Our Case Number: PL-500676-CE-26

An
Coimisiún
Pleanála

Re: Permission for a Solar Farm and all associated site works. The development is covered by the provisions of the Renewable Energy Directive III. A Natura Impact Statement (NIS) has been submitted with this planning application Ballycunneen, Drumline, Ballycasey More, Clonmoney West, Firgrove & Ard Kyle, Co. Clare.

In accordance with section 132 of the Planning and Development Act, 2000, (as amended), you are required to submit, on or before **29 July 2026**, the following information in respect of the proposed battery energy storage system component of the development, as set out below:

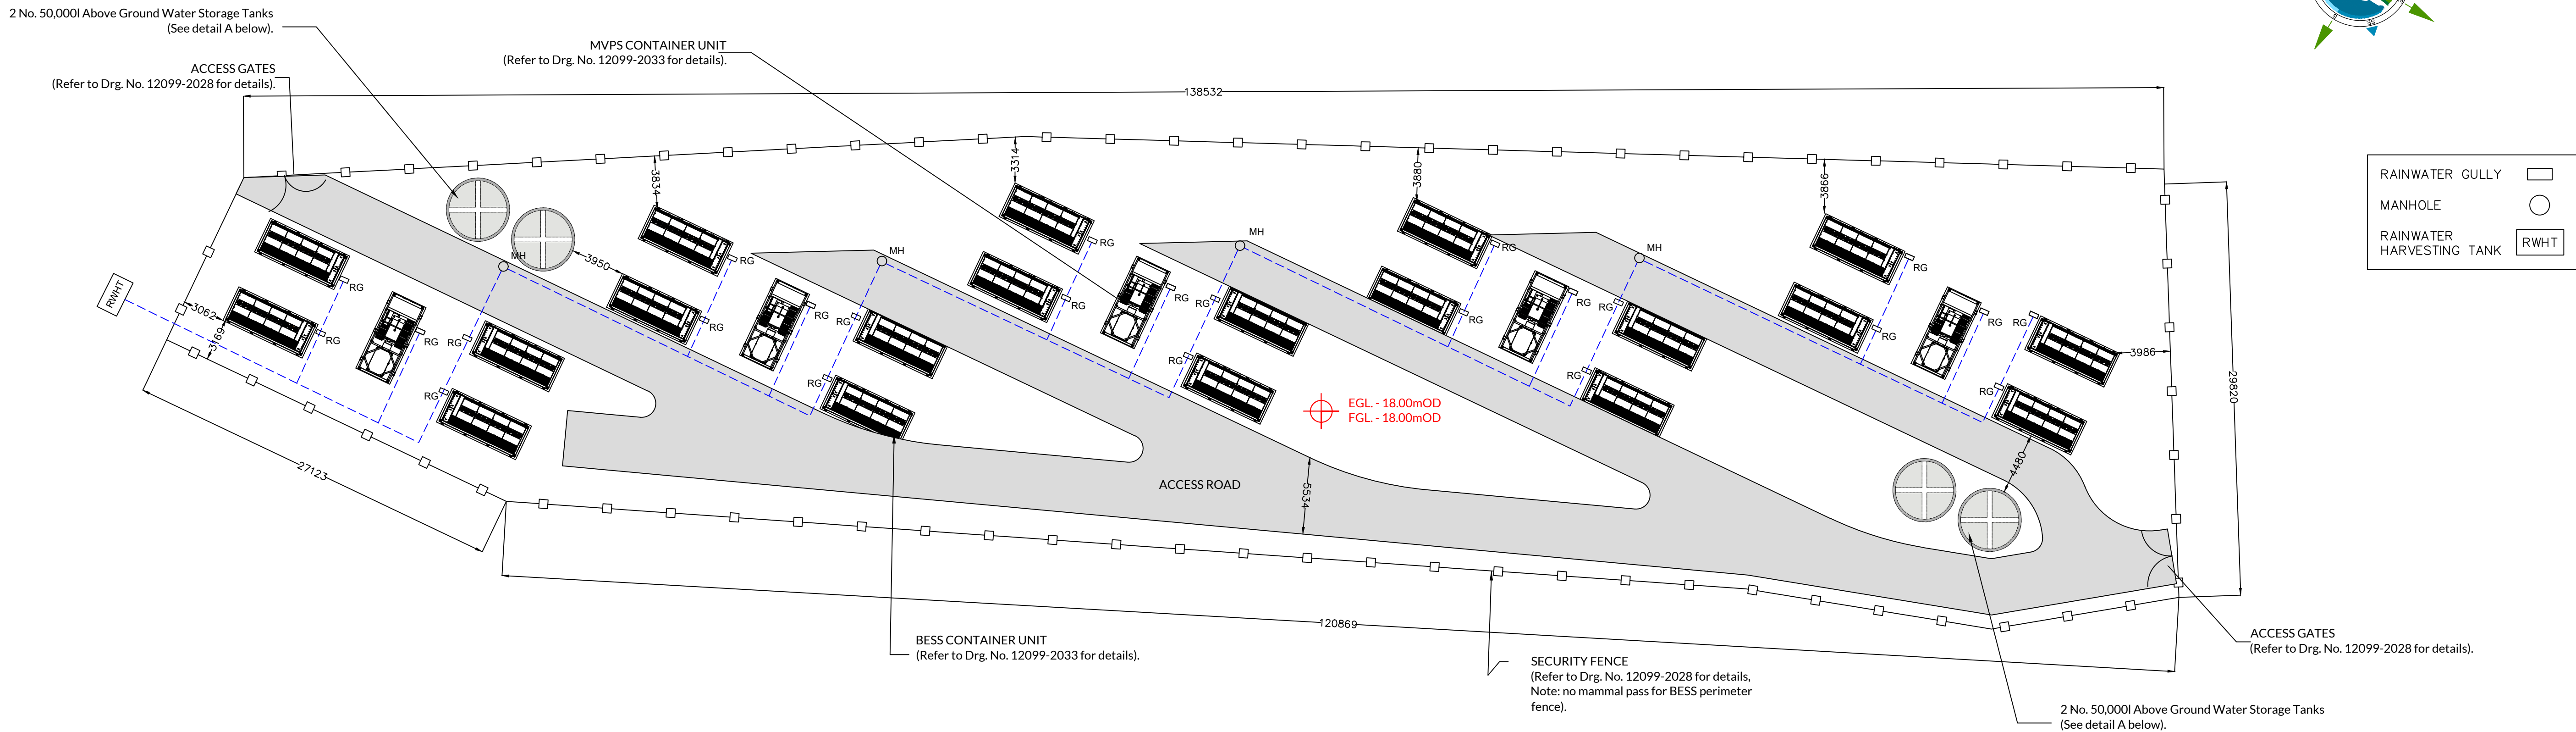
3. A key environmental consideration during a fire event is the run-off of fire water into onsite and adjoining watercourses, including the Shannon Estuary. Further detail and mitigation is therefore required demonstrating that there will be no contamination of surface water or groundwater, that suitable catchment and containment measures would be in place for firewater runoff, and other potential firefighting substances and chemicals (such as foam), and that consideration has been given to potential downstream impacts.

4. Please provide details as to the proposed means of accessing an adequate dedicated water supply to facilitate the development and implementation of a rapid and effective firefighting response.

Figure 0.2: Transect Routes

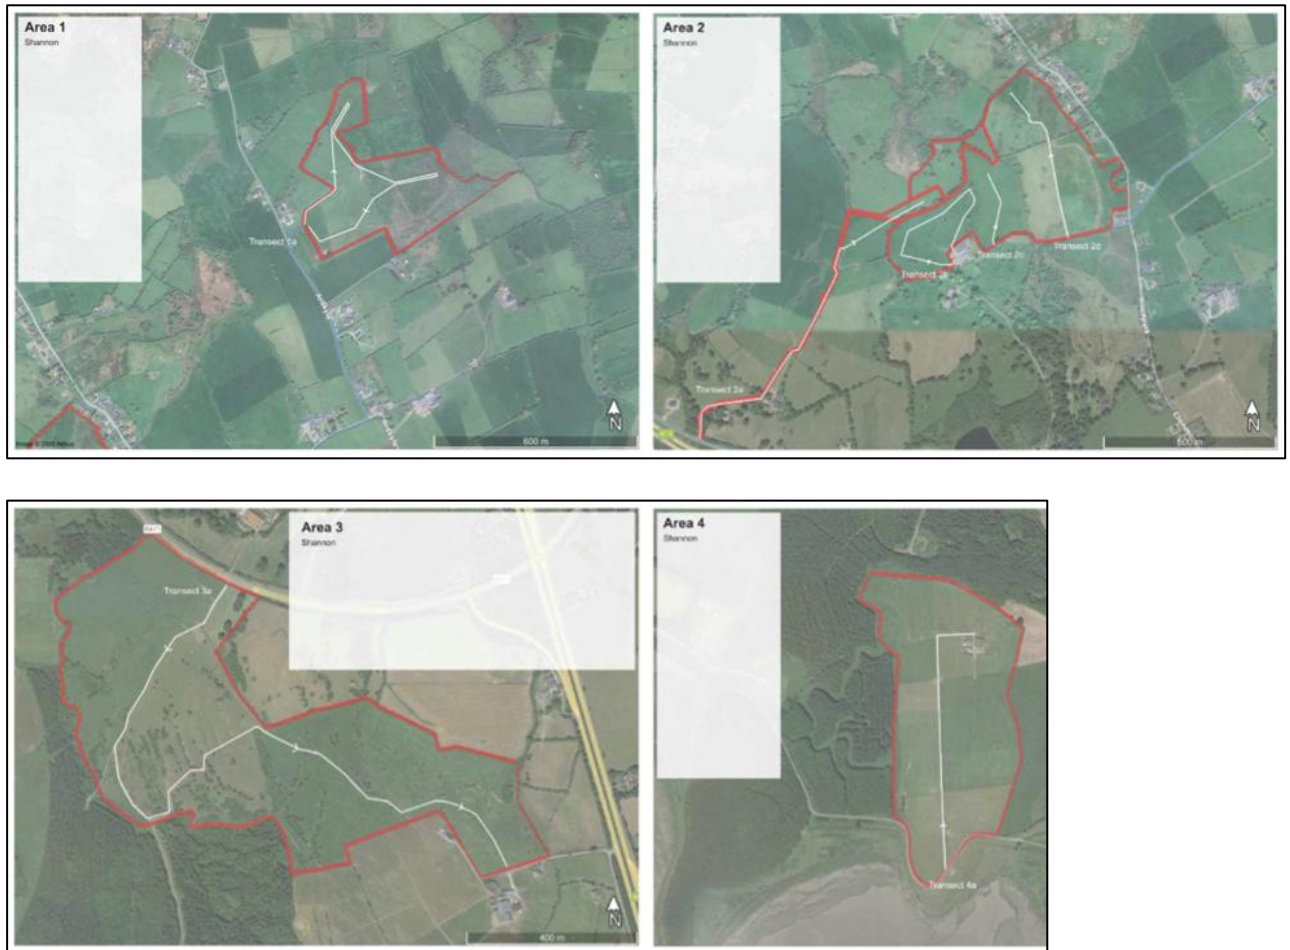
8. Required to confirm if the bird transect surveys conducted for proposed Land Parcel 4 (i.e., the southernmost parcel) – which is immediately adjacent the River Shannon and River Fergus Estuaries SPA (Site Code: 004077) – were scheduled around the tidal cycle / different tidal states to capture potential species movement, foraging activity, and high-tide roosting patterns, which could potentially be associated with this designated site.
